STATE OF WASHINGTON
DEPARTMENT OF ECOLOGY

Thank you for the opportunity to provide additional comments on the optional determination of non-significance process for the cluster plat of approximately 21.03 acres into 14 lots, proposed by Todd and Terry Geiger [P-07-53], also known as Dakota Heights LLC. We have the following additional comments to Ecology's previous letter dated February 12, 2008:

Log: 021508-06-KT
Property: Dakota Heights PBC Plat, File # P-07-53
Re: Archaeology - Survey Requested

DAKOTA HEIGHTS
PERFORMANCE BASED CLUSTER PLAT
KITITAS COUNTY, WASHINGTON

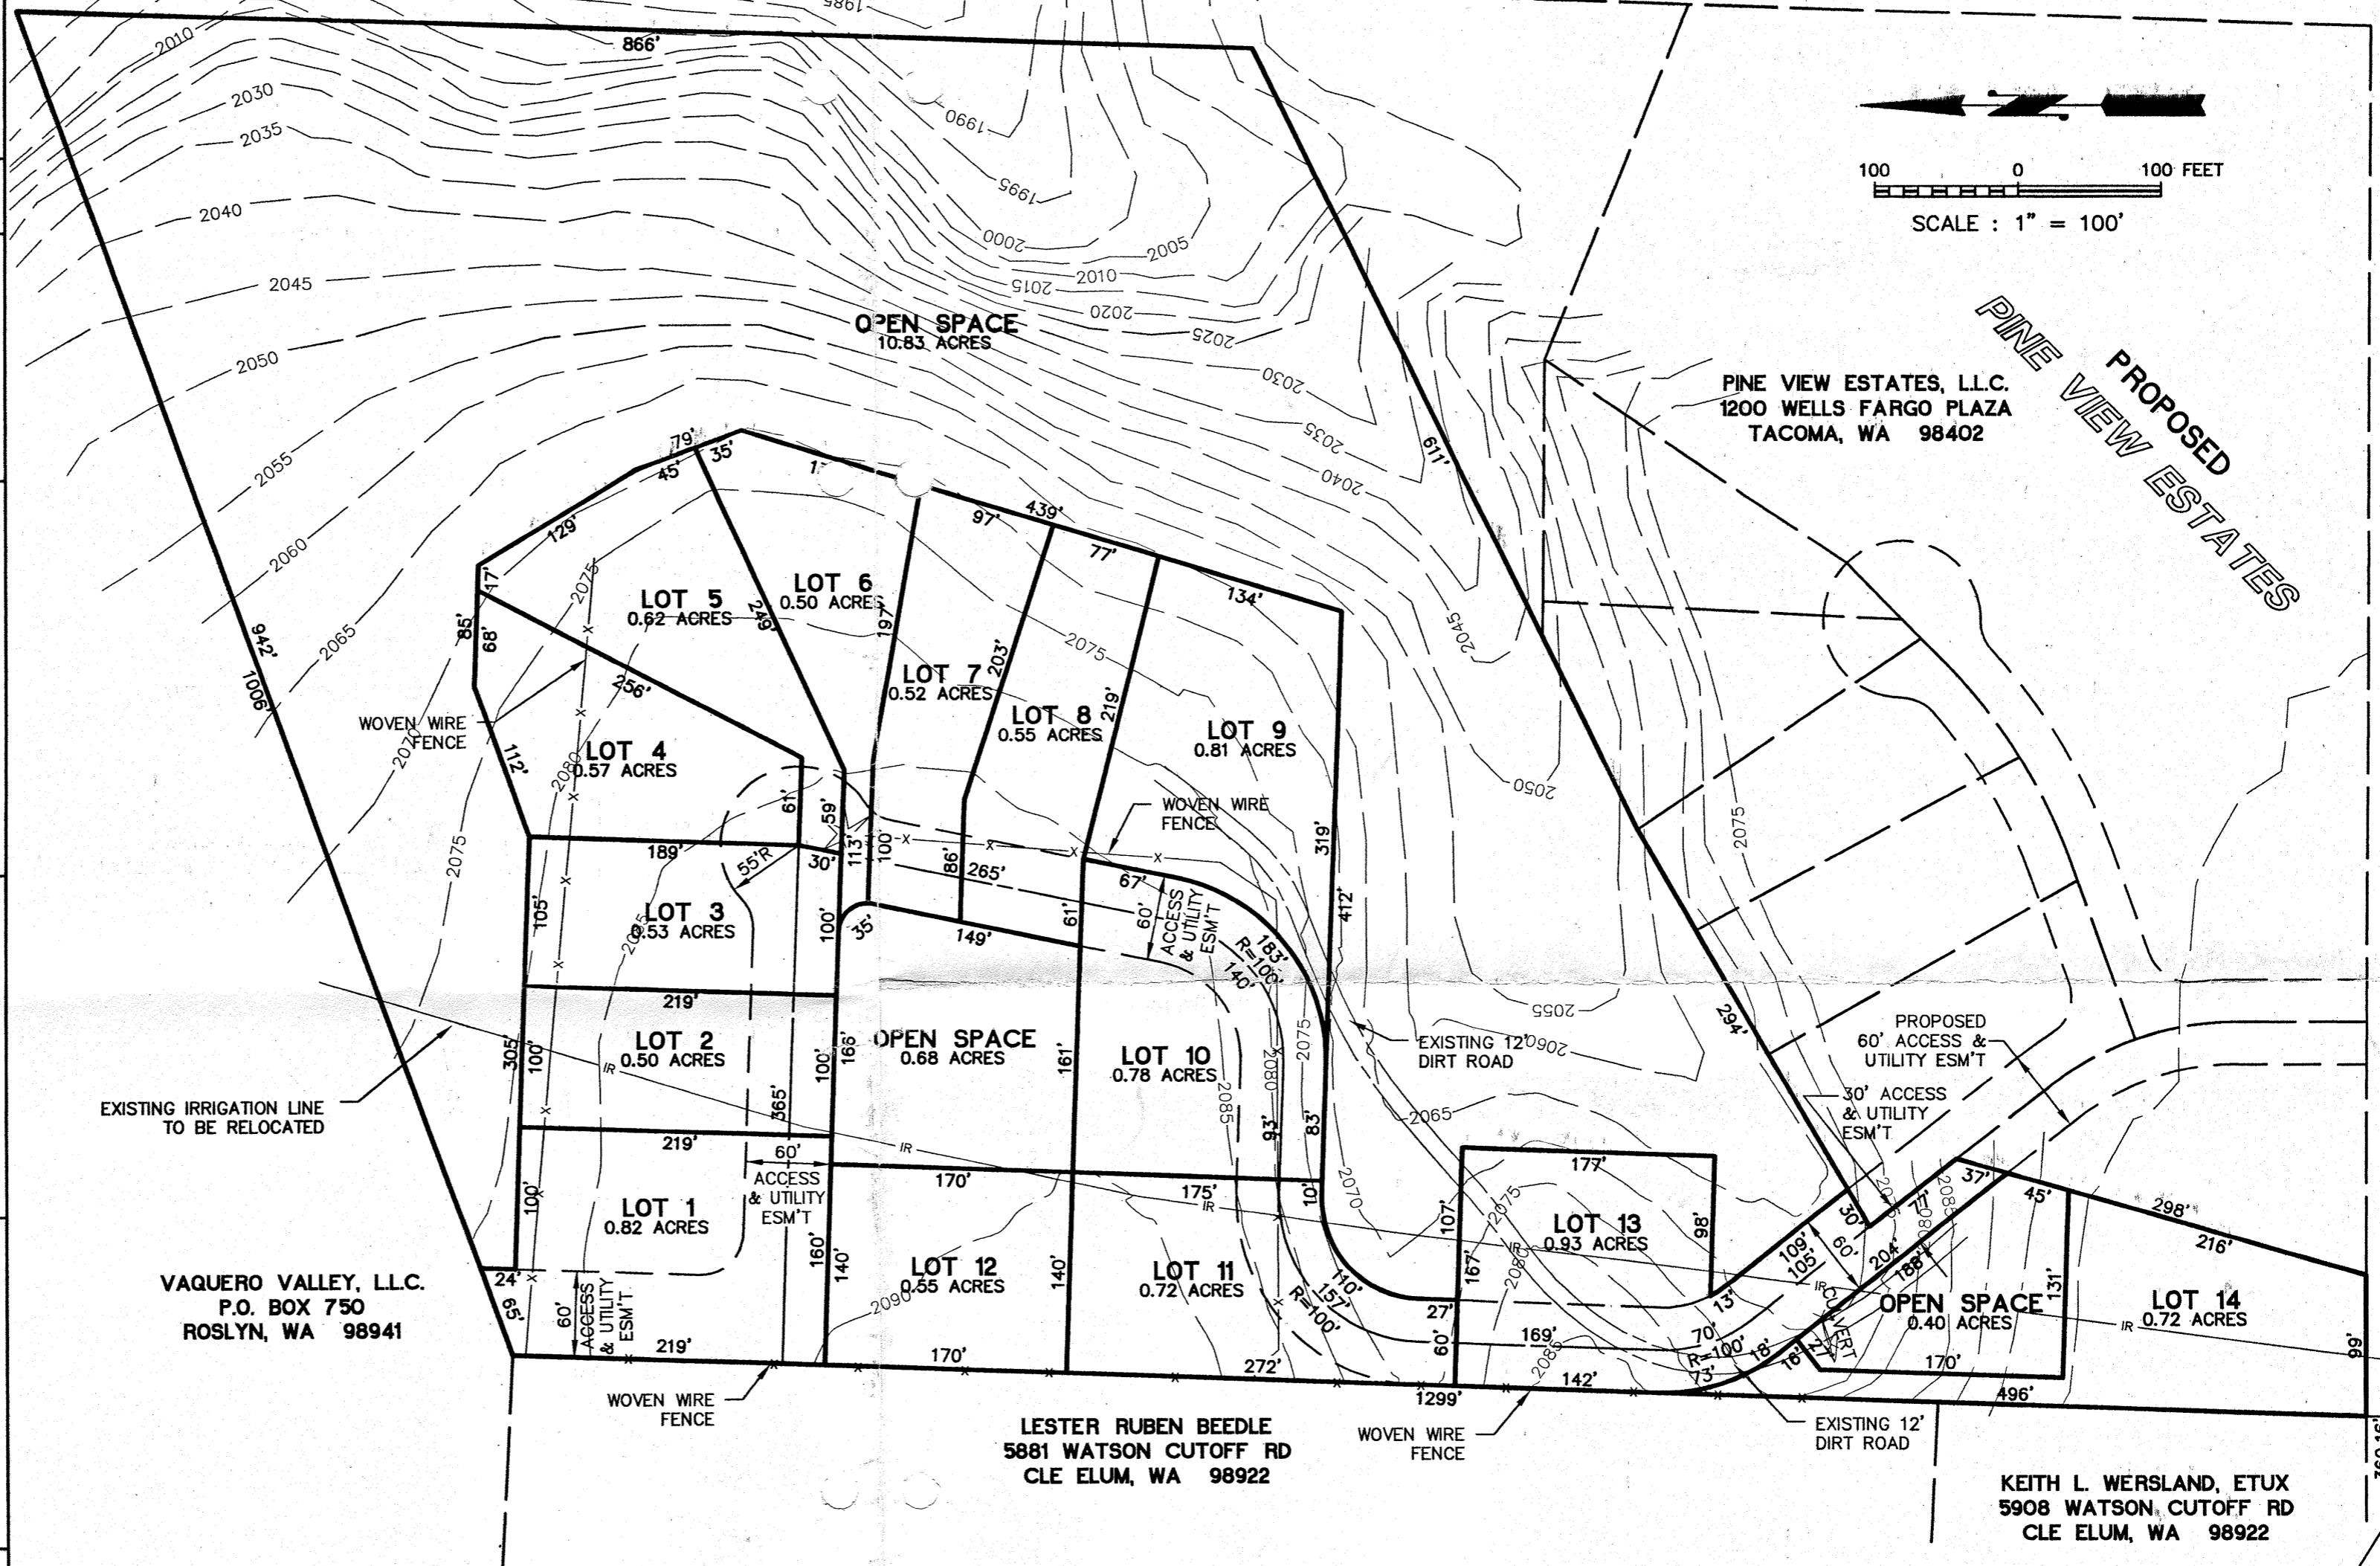
According to the map attached to the current proposal, File No. P-07-53, roads will be shared with adjacent parcel No. 1916060100008. This adjacent parcel, owned by Pine View Estates LLC, was one of the original 14-lot Performance Based Cluster Plat (File No. P-06-20). Since there are still common facilities, interconnected plans, and relatively contemporaneous development of the two parcels which derive from a common parcel recently created, it is our opinion that the Dakota Heights parcel no. 1916060100019 continues to part of a larger a larger project. In other words, the change in ownership has not altered its status as part of the proposed group use.

a.) applicant states "Upper Peoh Pointe Rd." as the access, when, in fact, access must first go through Pine View Estates, where they will share a road.
